Your ref: 3/2016/0124
Our ref: DC/16/593
Date: 22-FEB-16

Location: Land off Chatburn Old Rd, Chatburn

Proposal: discharge of condition 6 - foul and surface water drainage

NOTE THIS DRAWING IS FOR PRICING PURPOSES ONLY

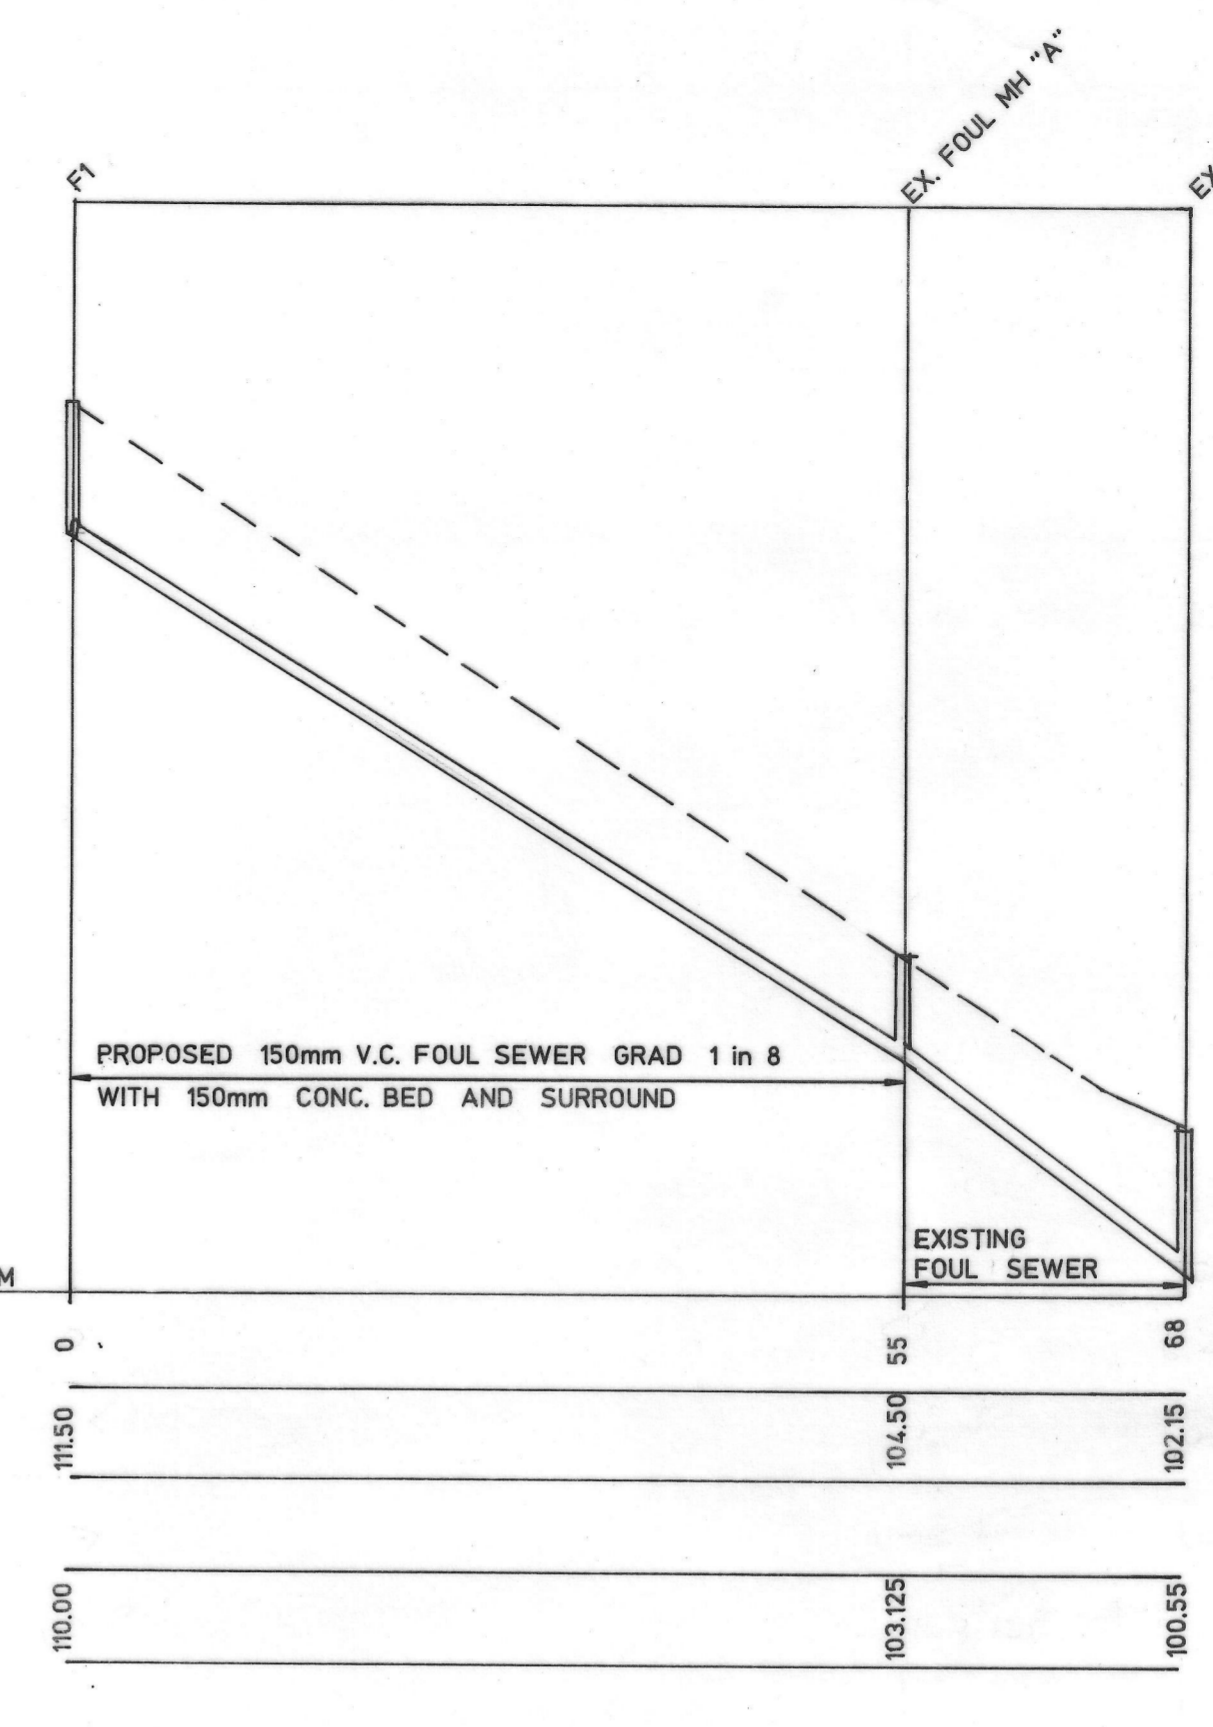
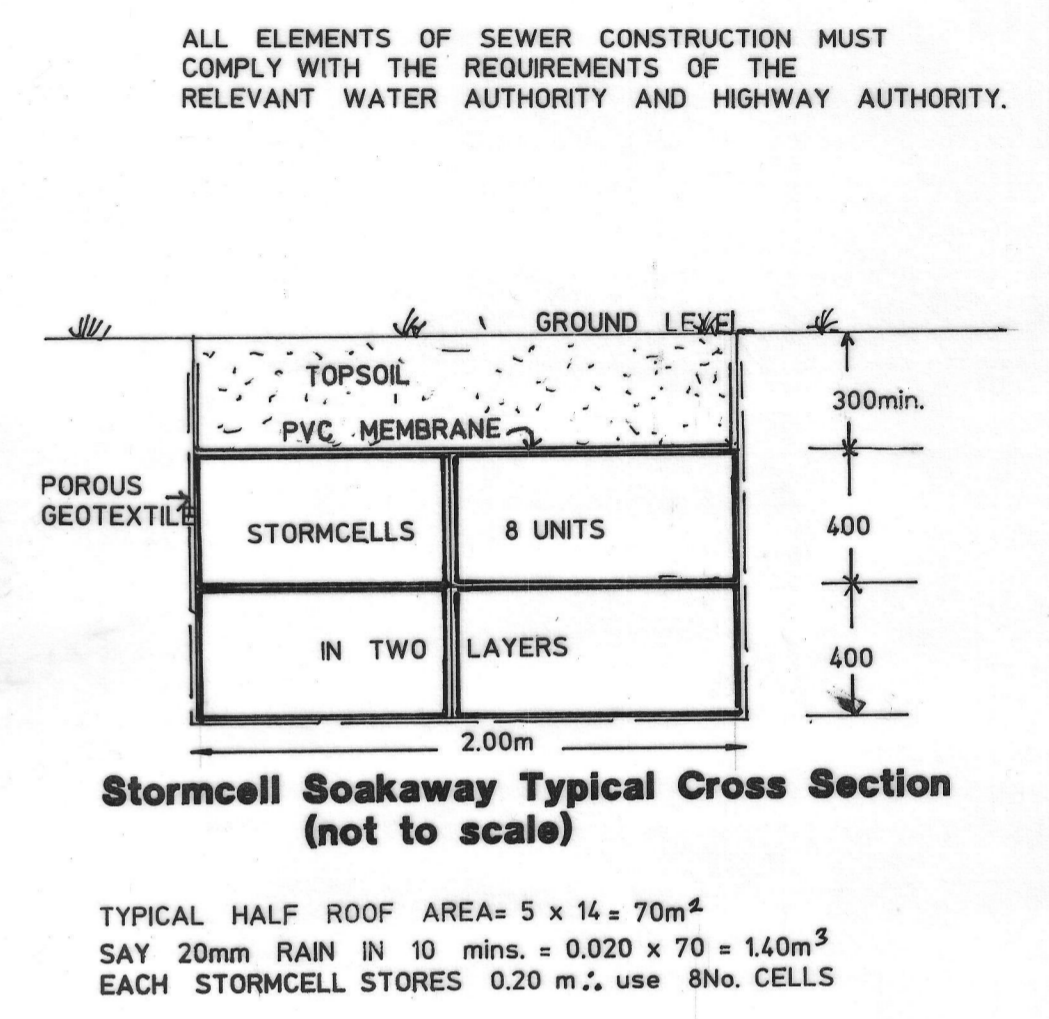
With reference to the above application, United Utilities are unable to discharge conditions relating to drainage. It is unclear where the developer intends to drain the public high way.
